Subject: RE: SG-12-00005 Schnebly Notice of Application
Attachments: Schnebly.doc

August 13, 2012

Re: Schnebly (SG-12-00005)

PROPOSED

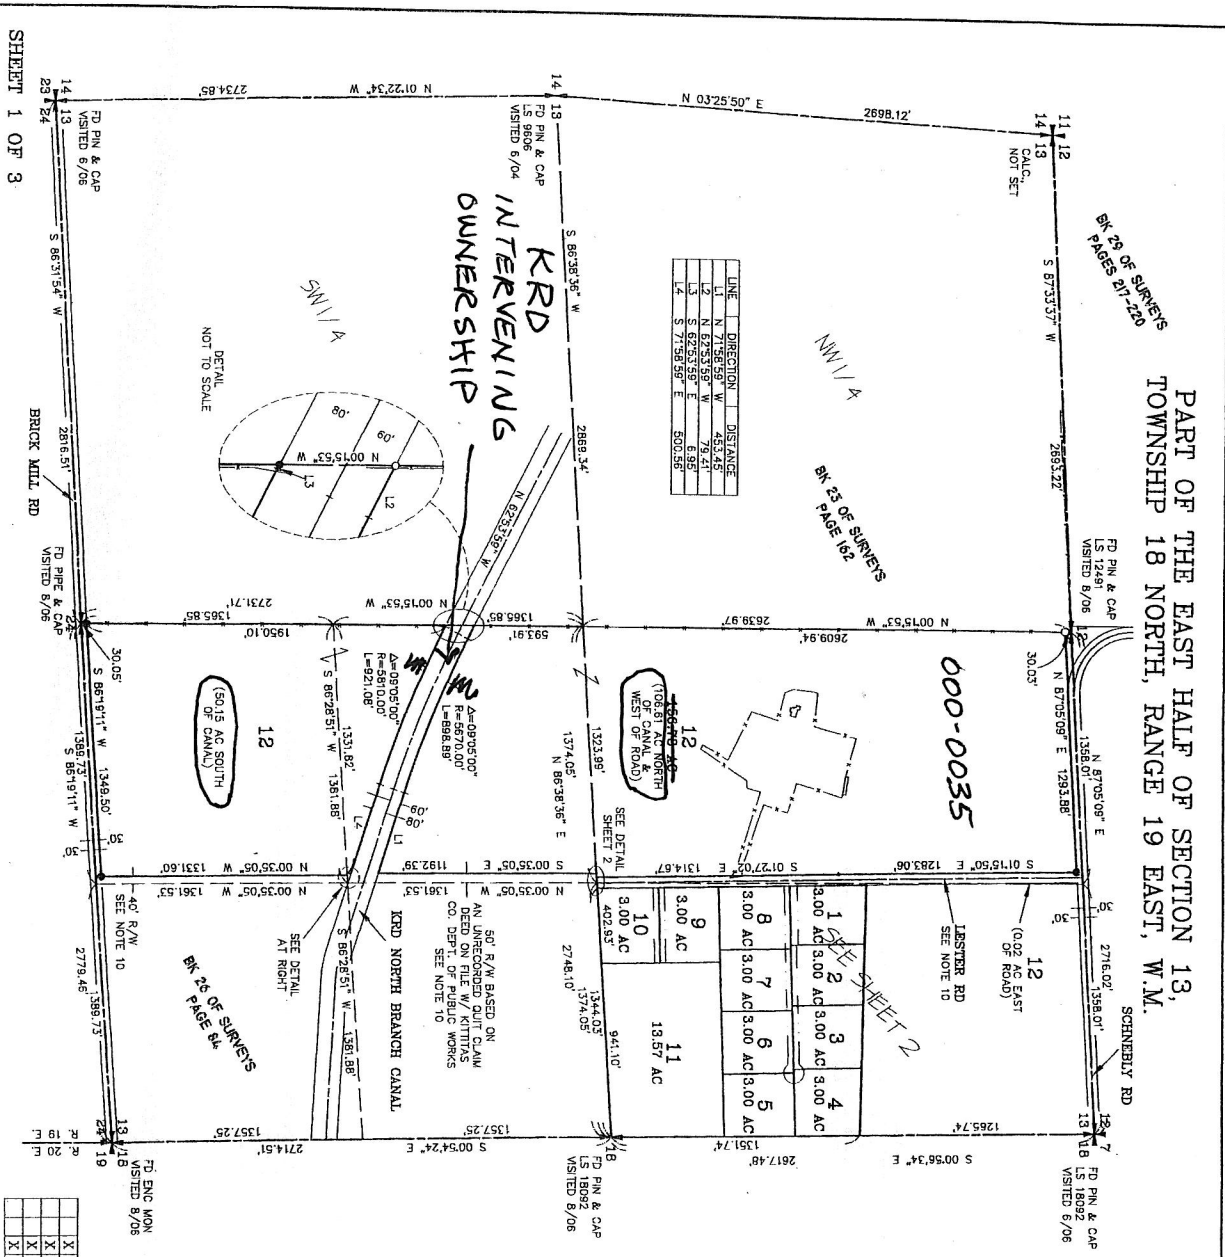
- Ensure that the segregation does not infringe upon existing structures, to include propane tanks, etc.
- Creation of any additional roads or access must comply with the International Fire Code.
- If access to the property is across the canal, any new bridge shall be permitted through this office and shall be constructed to meet the minimum requirements of 75,000 lbs live load. An existing bridge shall be certified by an engineer that it meets those requirements.
- All future development must comply with the International Fire Code.
